YorkshireWater

Your Ref: 2016/92298
Our Ref: S011274

3rd August 2016

former North Bierley Waste Water Treatment Works , Oakenshaw - Re-development of former waste water treatment works following demolition of existing structures to provide employment uses (use classes B1(c), B2 + B/8) - 38,090m2 + residential use (use class C3)

ILLUSTRATIVE MASTER PLAN

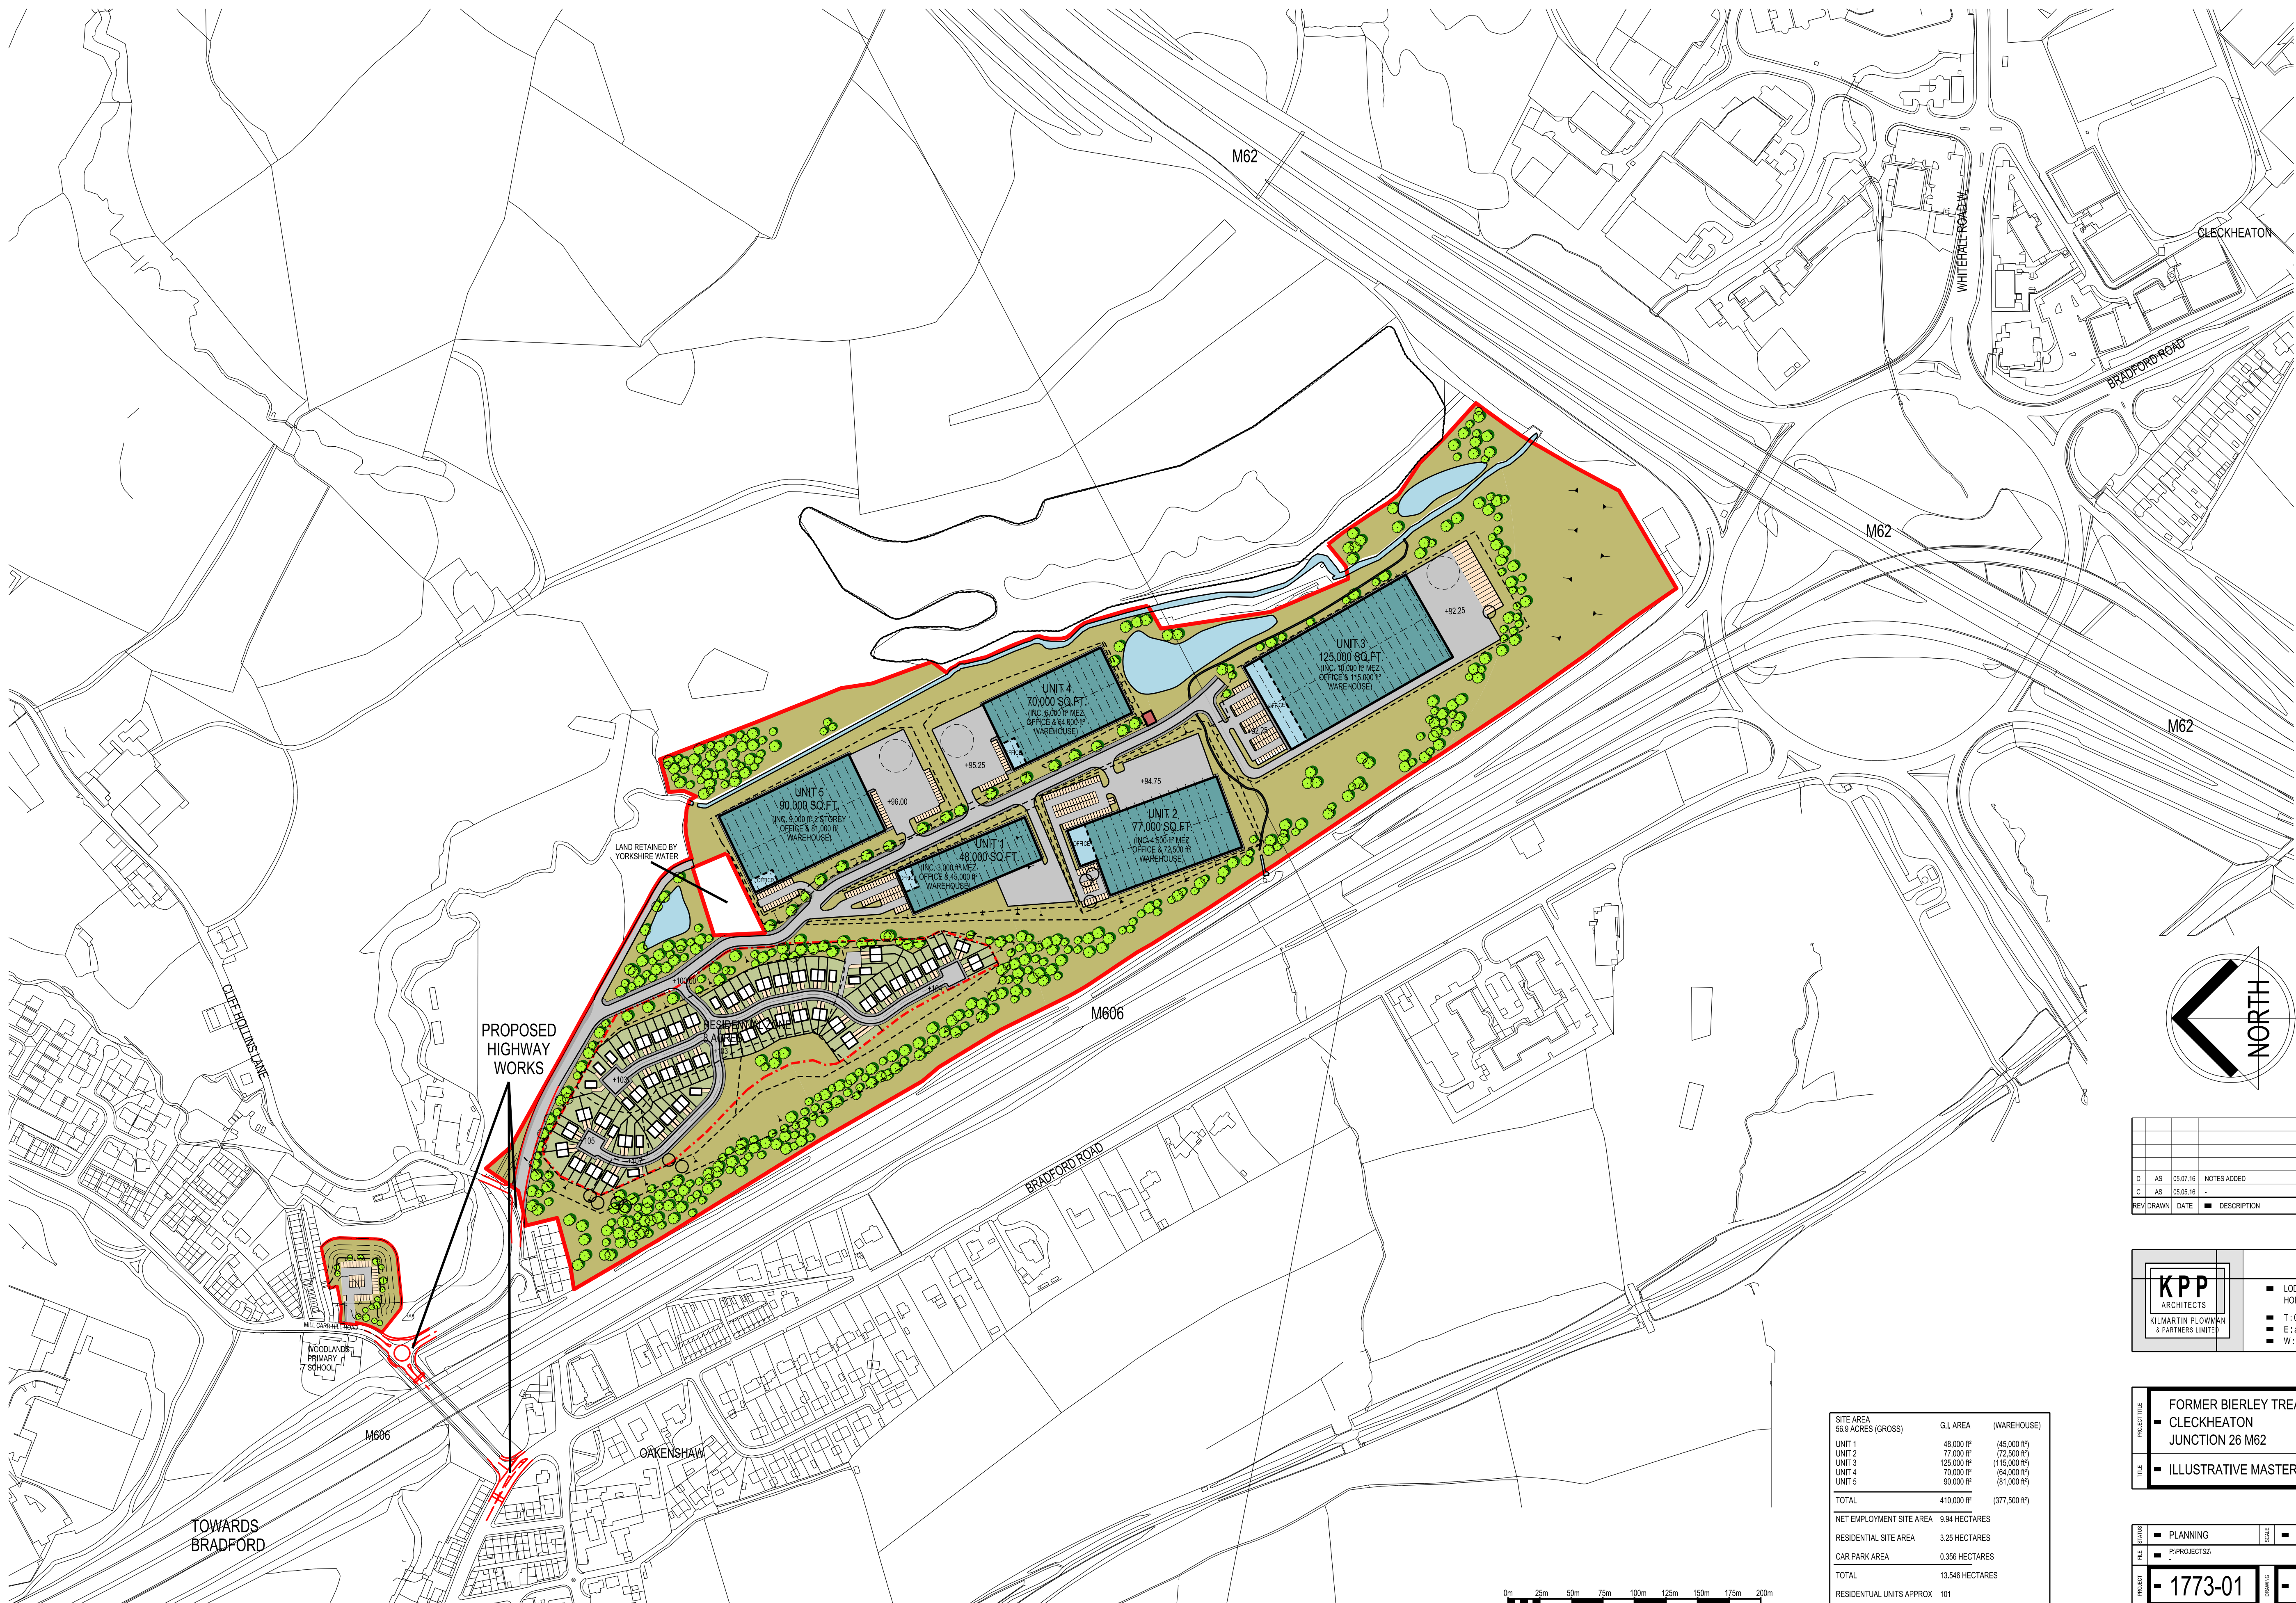
In this instance, a stand-off distance of 6 (six) metres is required at each side of the above sewer centre-lines. YWS would look for the protection of the 100 mm diameter public sewer to be controlled by Requirement H4 of the Building Regulations 2000. The submitted drawing appears to show trees planted over the line of public sewer/YW maintained sewer. Tree's should not be planted within 5 (five) metres of these sewers (the matter can be controlled via condition).

2) The site layout details submitted on drawing 1773-01-206 (revision D) dated 05/07/2016 that has been prepared by KPP Architects are NOT acceptable to Yorkshire Water. It appears that there would be inadequate access arrangements to Moorend CSO/YW Syphon sewer. Yorkshire Water require unhindered 24/7 access to this critical asset for large vehicles. The developer must provide a formal access route prior to commencement of development.
